**KIRKLEES METROPOLITAN COUNCIL
INVESTMENT & REGENERATION SERVICE**

DELEGATED DECISION TO DETERMINE PLANNING APPLICATIONS

Reference No:	2024/62/93293/E
Site Address:	17, Honeysuckle Lane, Soothill, Batley, WF17 6FN
Description:	Erection of 2 storey rear extension with balcony
Recommending Officer:	Jennifer Booth

OFFICER REPORT

Drawing Title  
 PROPOSED

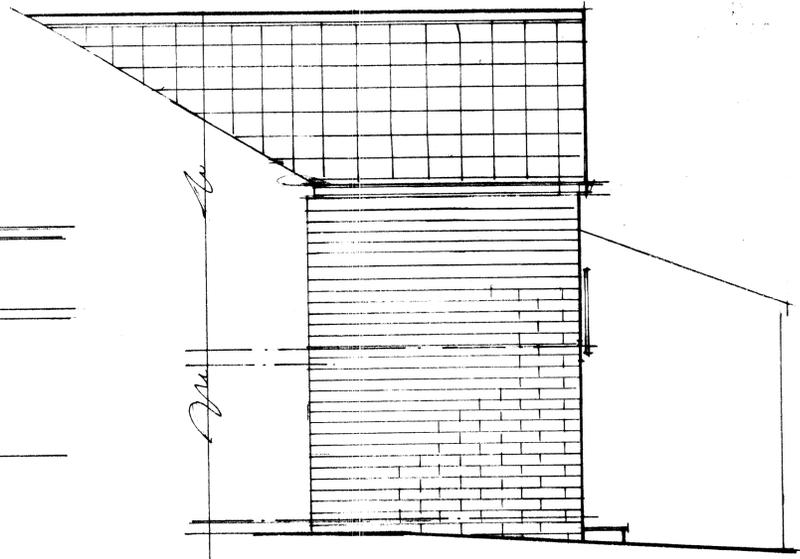
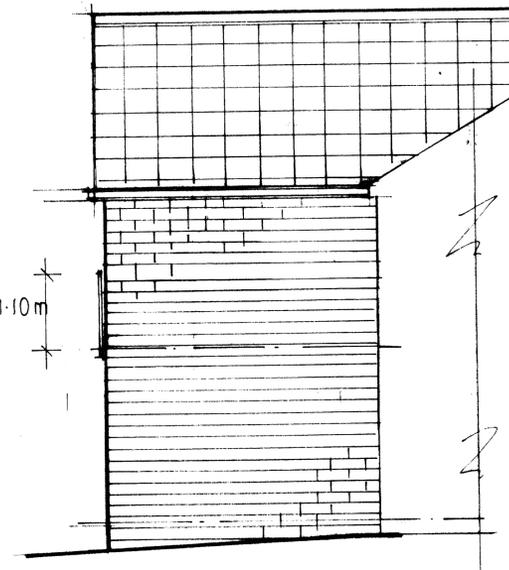
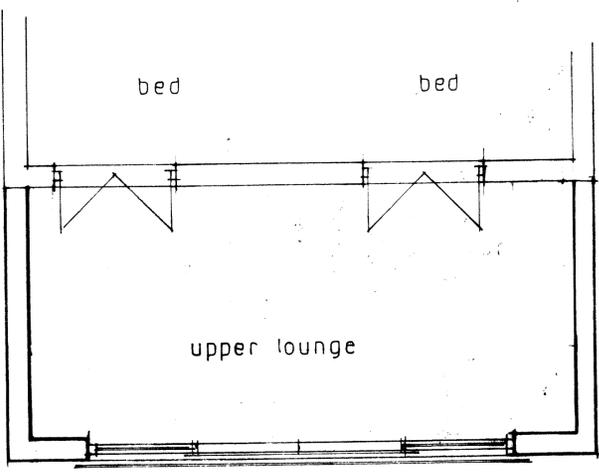
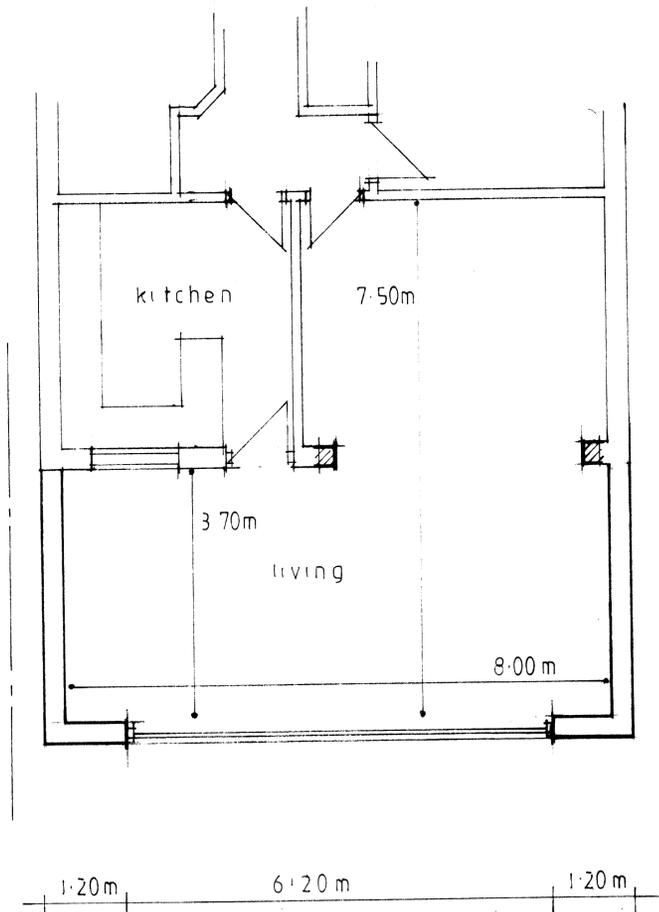
- Loss of privacy from the balcony- **Response:** *privacy is a material consideration as it relates to residential amenity. The balcony element of the scheme has been omitted.*

- The flat roofed extension proposed would be out of character with the new development – **Response:** *this is a material consideration as it relates to visual amenity. Amended plans have been provided which altered the roof form which would now form a more appropriate relationship with the main house and surrounding properties,*

The initially submitted plans raised concerns in terms of the roof design, which was initially proposed to be flat. Amended plans were sought and received which changed the roof form to a perpendicular pitched roof form. The changes did not significantly alter the scale of the scheme and as such, the amended plans have not been advertised.
